Our ref: 09-181

28 September 2010

**RE: AUSTRALIAN HEARING HUB AT MACQUARIE UNIVERSITY
RTA COMMENTS ON PROJECT APPLICATION**

AUSTRALIAN HEARING HUB	
AUSTRALIAN HEARING HUB	AUSTRALIAN HEARING HUB
AT MACQUARIE UNIVERSITY	AT MACQUARIE UNIVERSITY
CIVIL WORKS PLAN	CIVIL WORKS PLAN
- BASEMENT 2	- BASEMENT 2

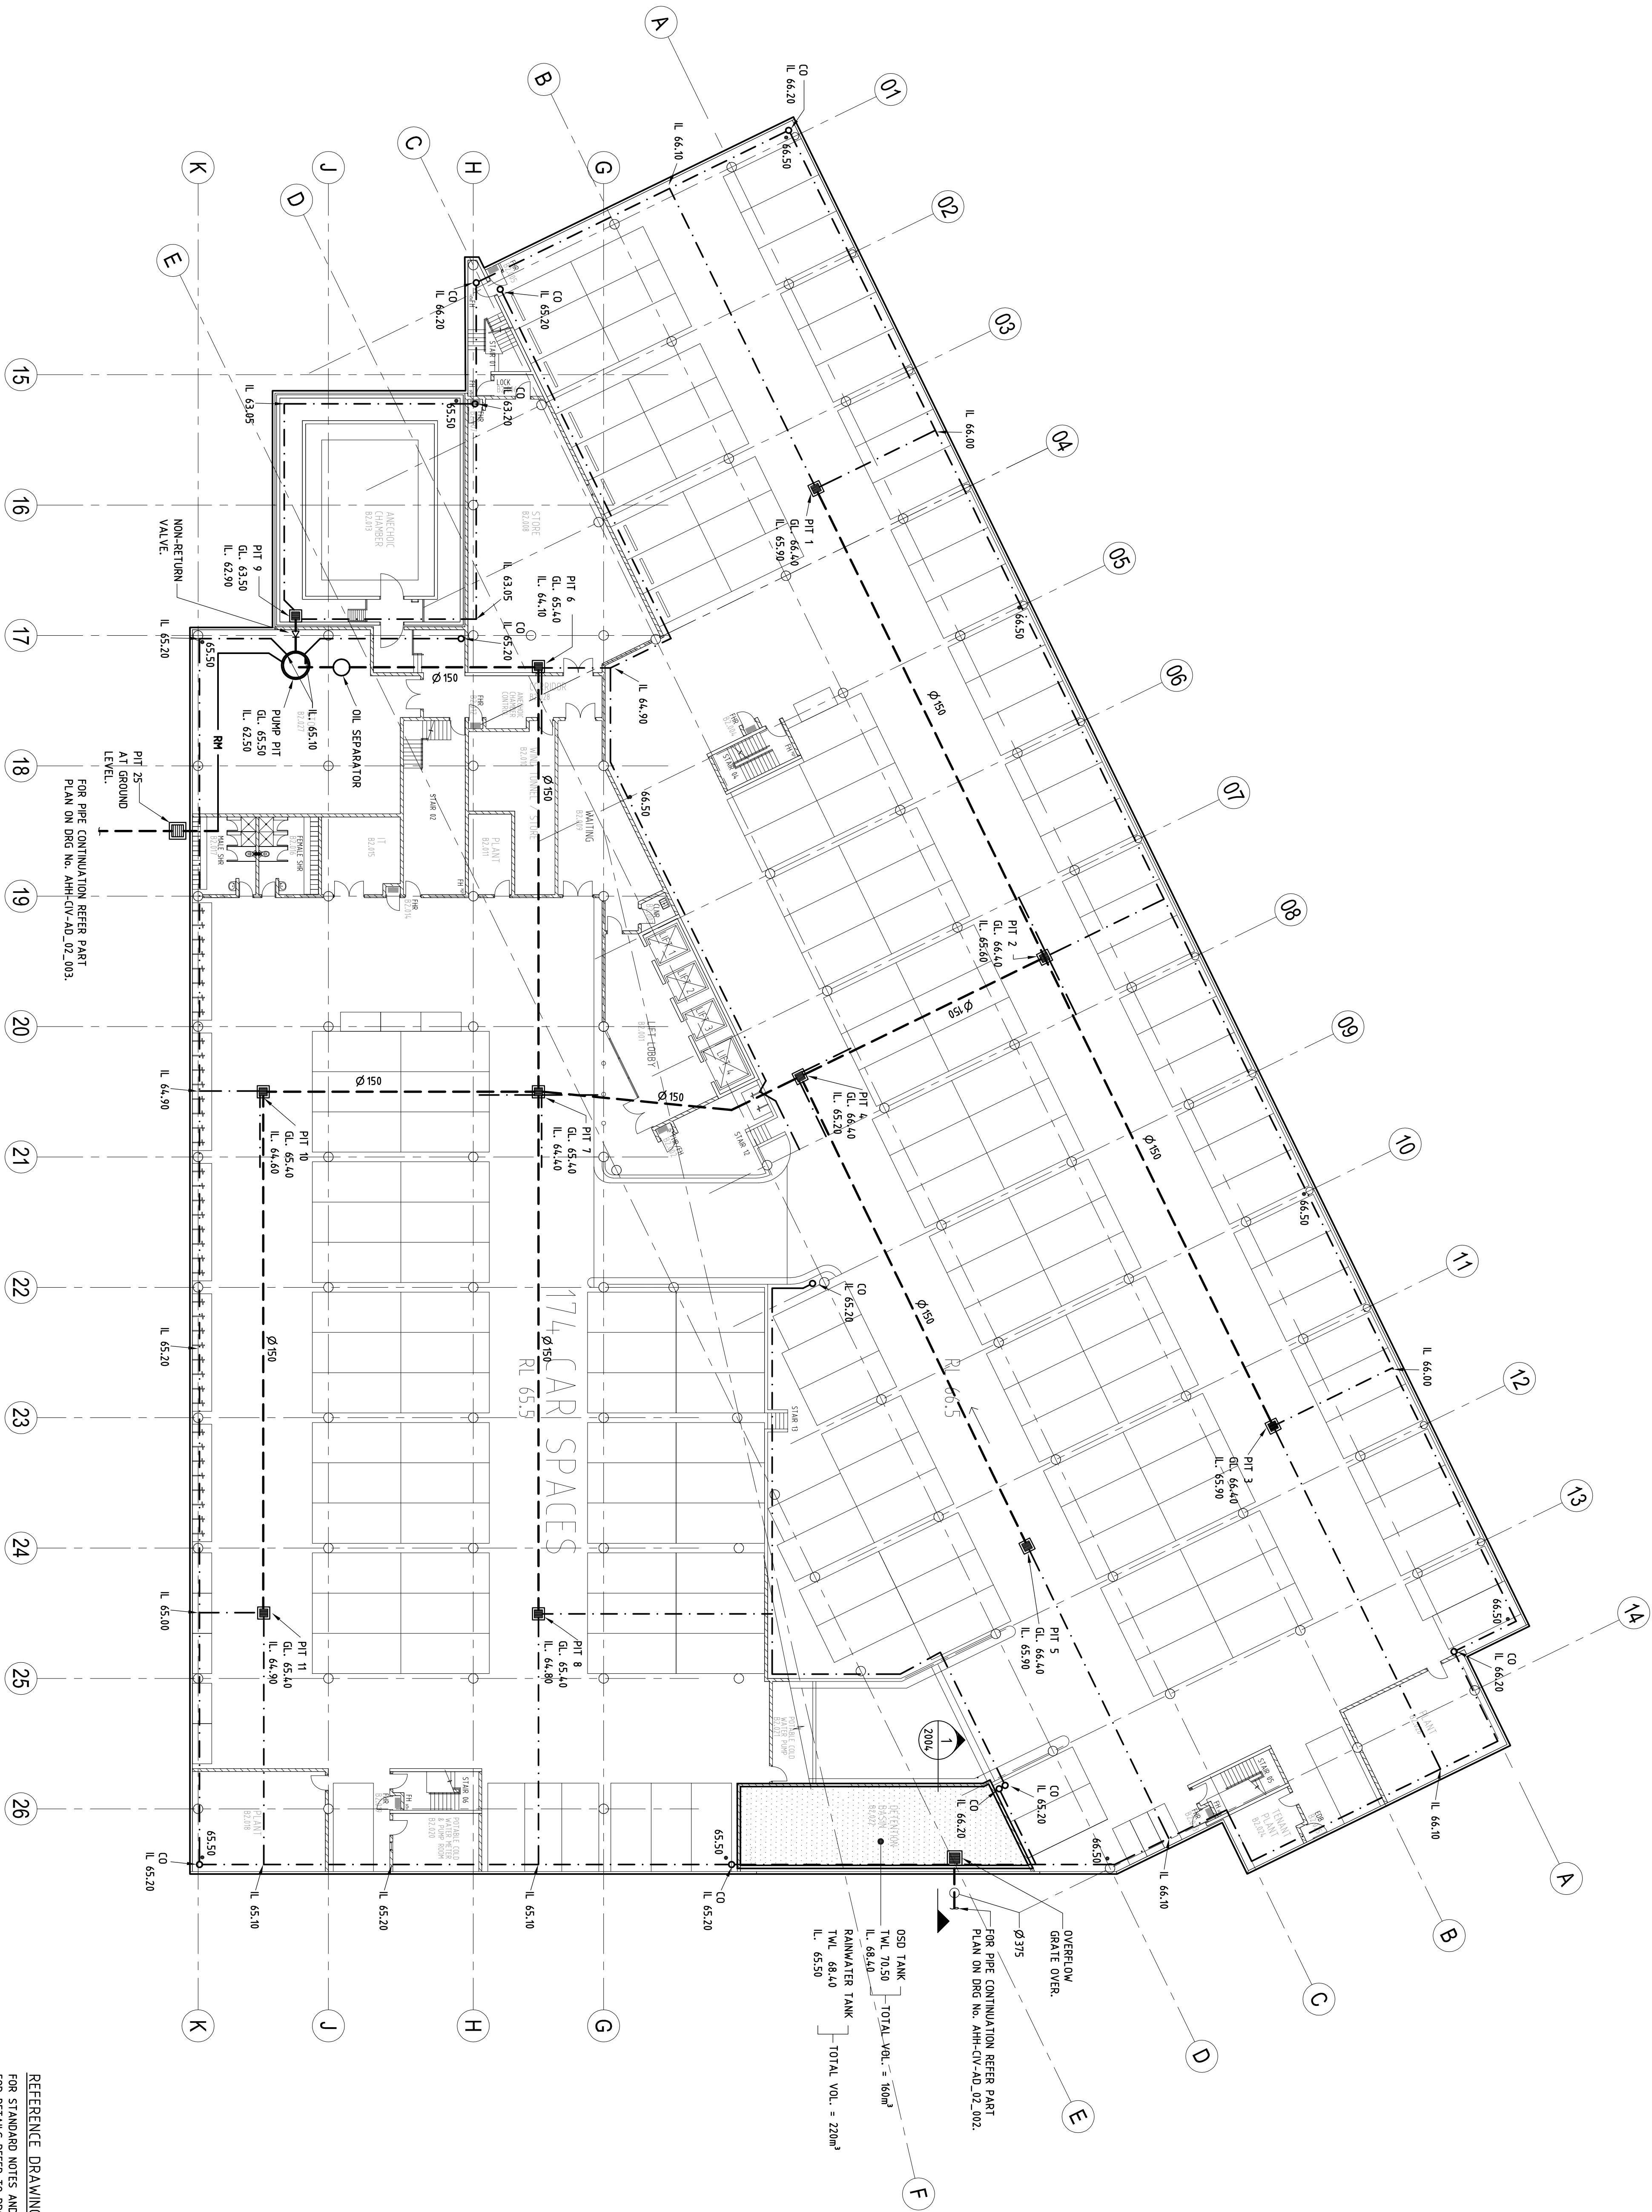
Reference is made to your email dated 27 September 2010 concerning the RTA's comments related to compliance of the layout of the proposed car parking area including the access road and entry with AS2890.1 – 2004 and AS2890.2 – 2002.

1. The car parking spaces, aisle widths, grades, turn paths and driveway comply with AS2890.1 – 2004 on the following basis.
 - User class 2.
 - Entry queuing permitted in local access road off University Avenue.
 - Stack parking spaces and blind aisles in excess of 6 spaces length, only used in tenant allocated car parking areas.
2. Access for commercial vehicles from University Avenue to the delivery area on Basement 1 level complies with AS2890.2 – 2002 on the following basis:
 - General access for Medium Rigid Vehicles.
 - Access for Heavy Rigid Vehicles through reversing into basement only.
